Wylfa Newydd DCO Examination

DCO Issue Specific Hearing (ISH) – Dafydd Griffiths on behalf of the NACP

Traffic and Transport – Non-Motorised Users (NMU)

Security Status	AS SHOWN	Sheet Size	A1	Sheet(s)	1 of 1
Drawing Number	WN0902-HZDCO-OHW-DRG-00002	Rev

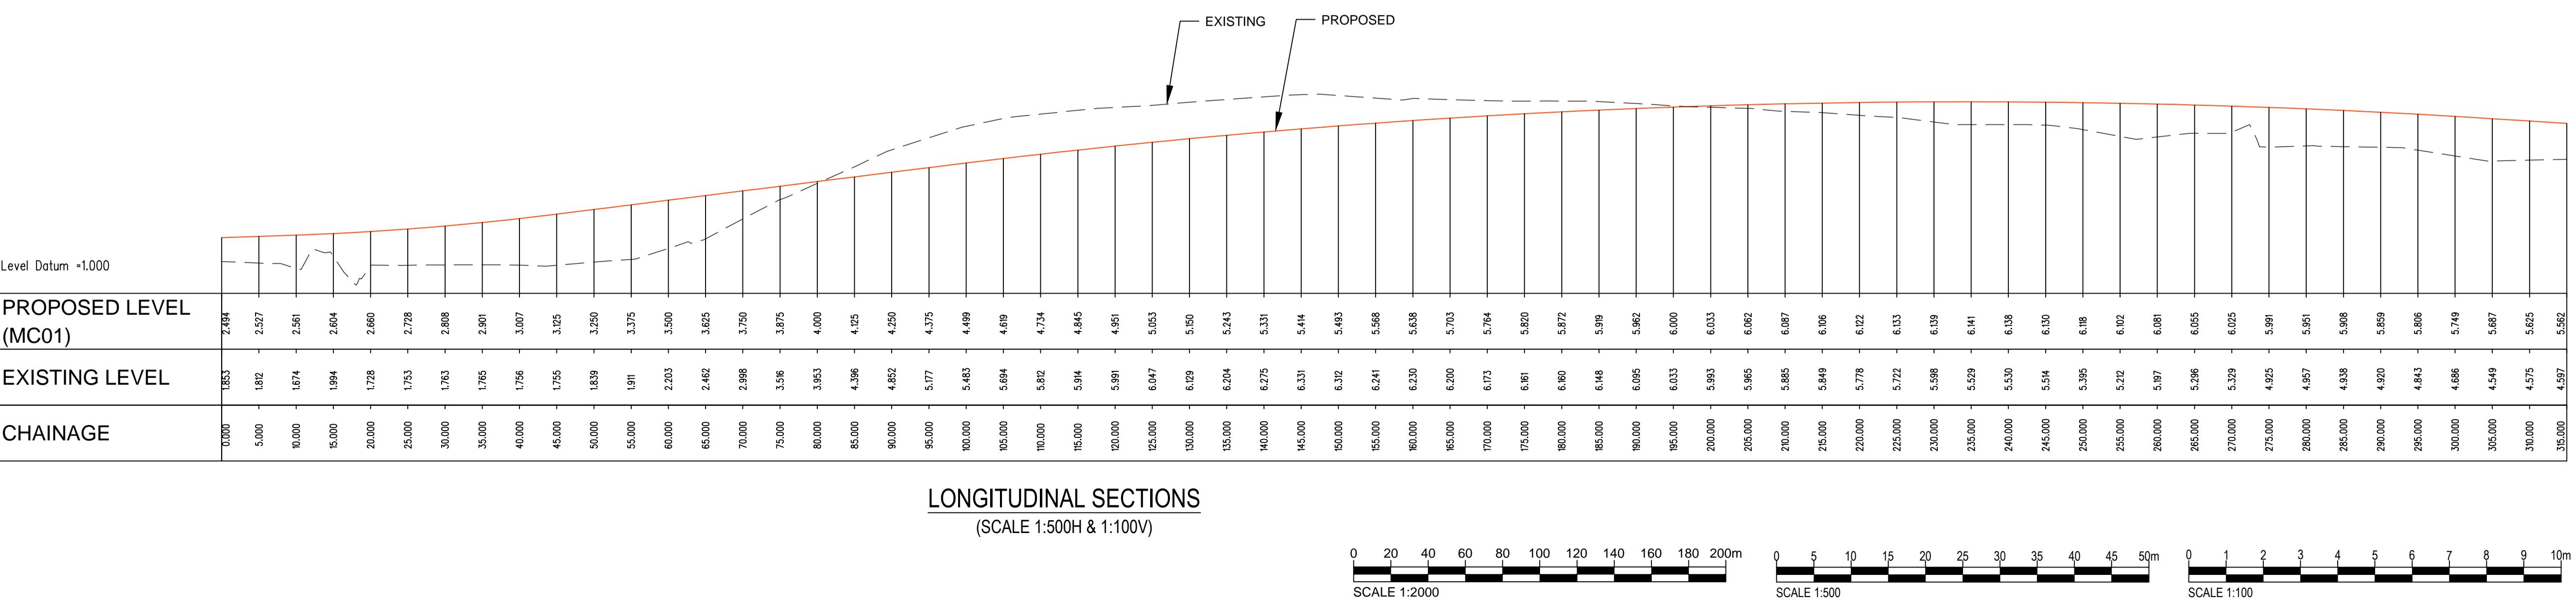
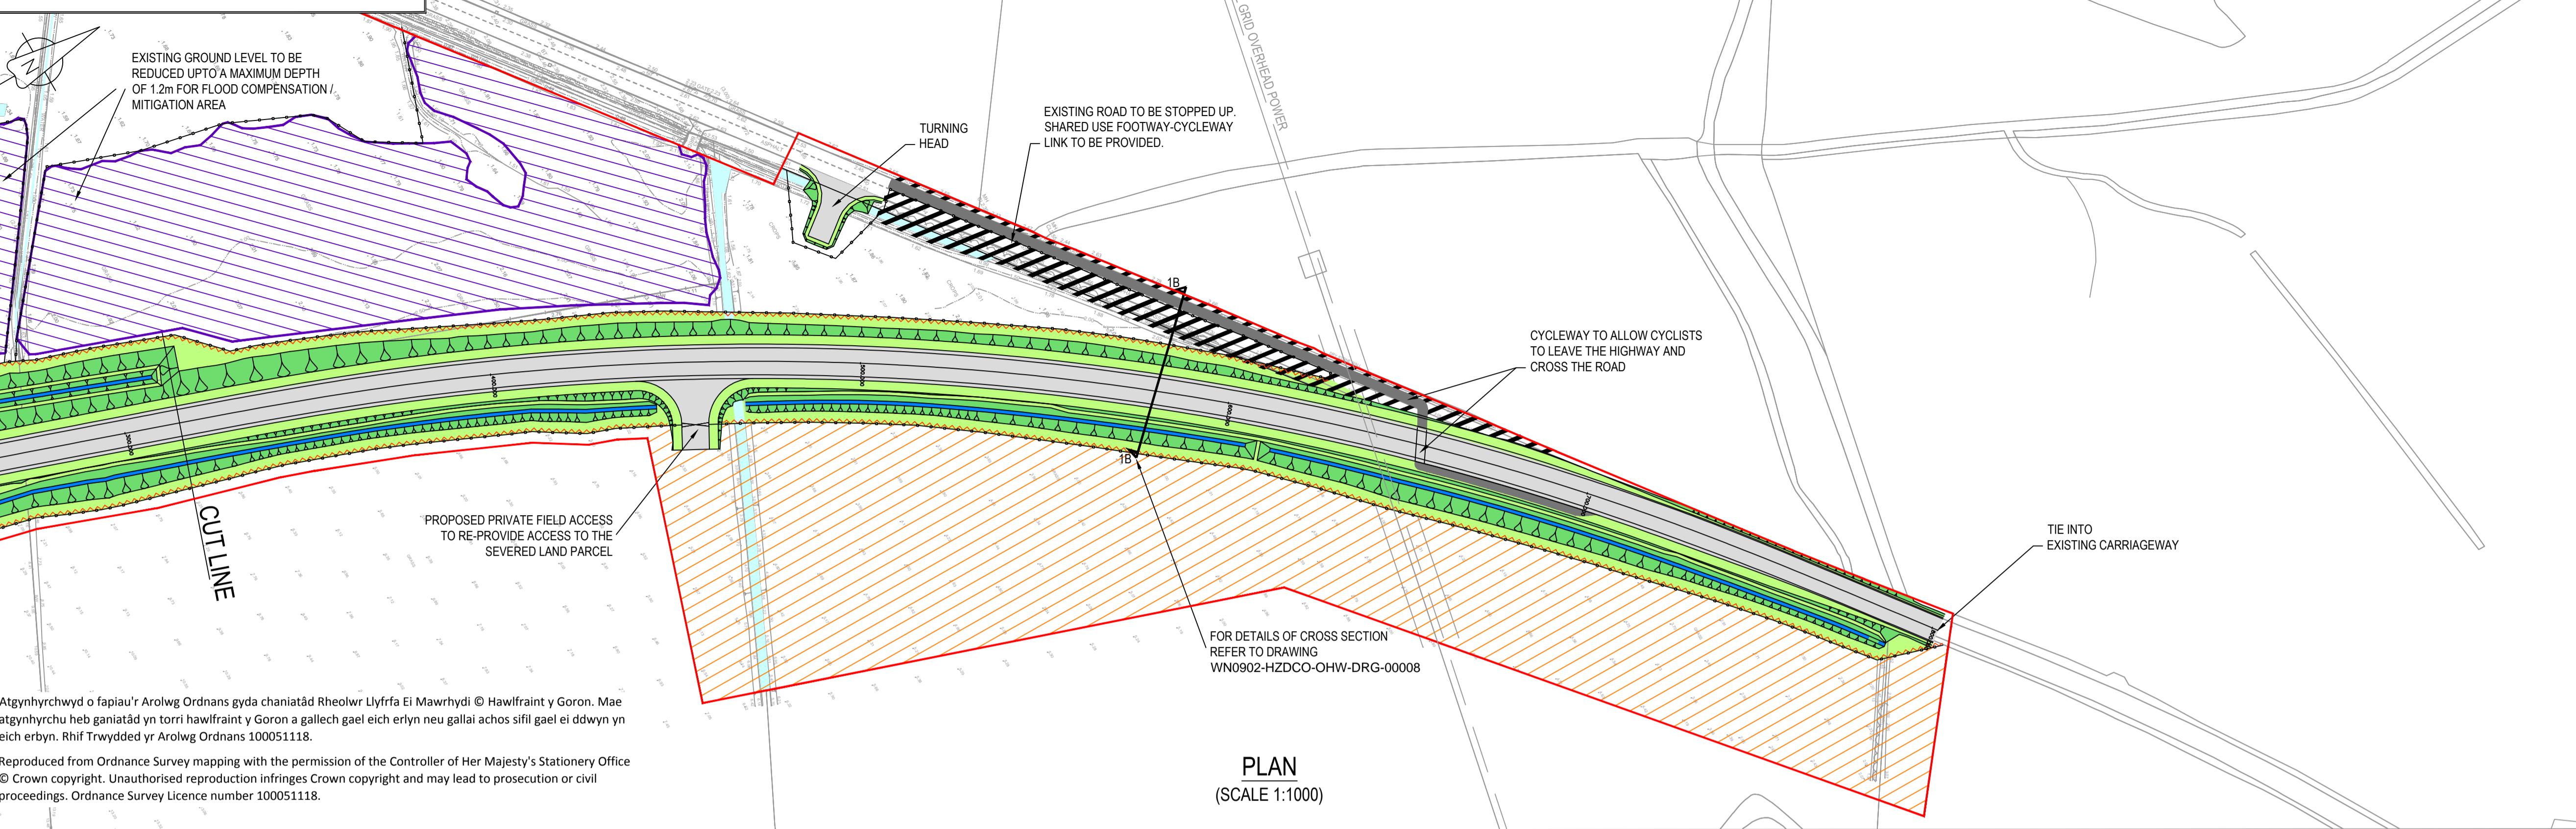
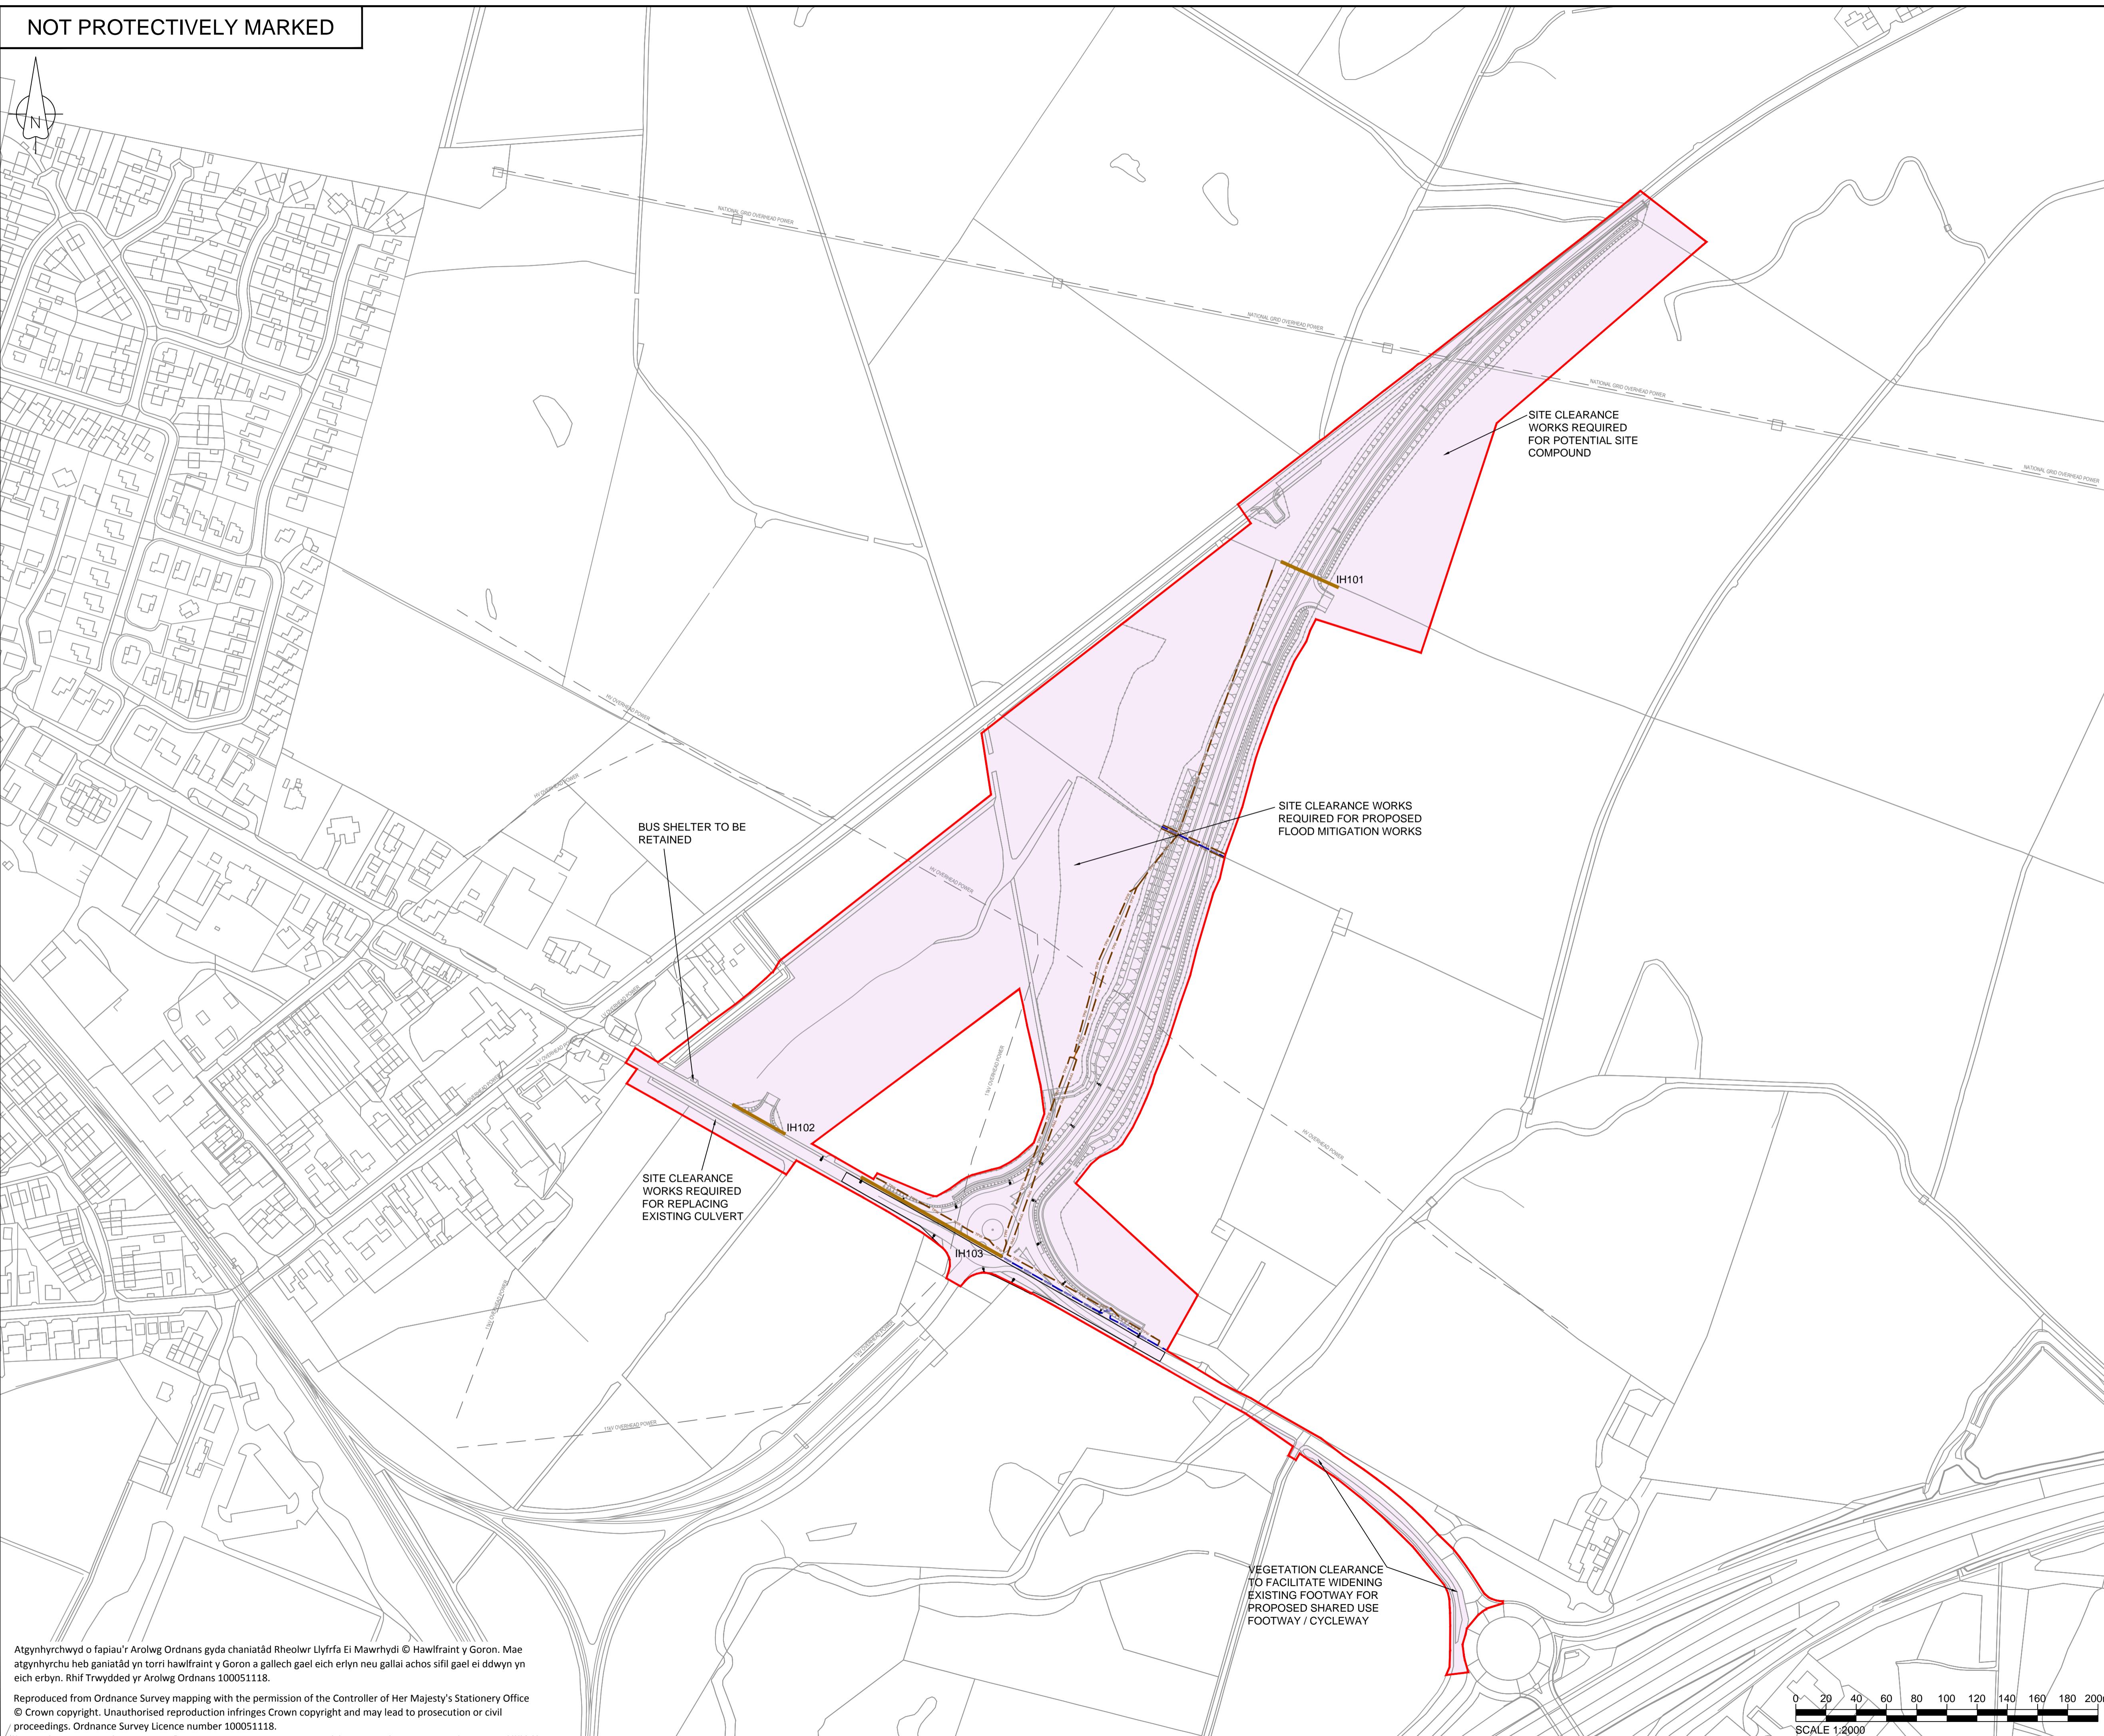
A note in the current plans as submitted indicate the following "EXISTING FOOTWAY TO REMAIN AND BE REDESIGNATED AS SHARED FOOTWAY" (APP-019 - WN0902-HZDCO-OHW-DRG-00002). On the 6th January 2019 the footway on this section was measured at several locations. The majority is between 1.8 and 1.4m wide and does not meet the standard that would be expected of a two way shared cycleway / footway. "The preferred minimum width for an unsegregated facility is 3.0m." However, "unsegregated shared facilities have operated satisfactorily down to 2.0m wide with combined pedestrian and cycle use of up to 200 per hour". (Design Manual for Roads and Bridges DMRB Volume 6, Section 3, Part 5, 7.16)

The use of the phrase "away from the carriageway edge" is misleading. What appears to be proposed is simply re-designating the narrow footway that runs between the two roundabouts as a cycling / pedestrian path.

Examining the drawings as submitted it is not clear what is proposed as NMU infrastructure between the new roundabout and the Valley traffic lights.

The current proposals are unacceptable and further appropriate mitigation is required.
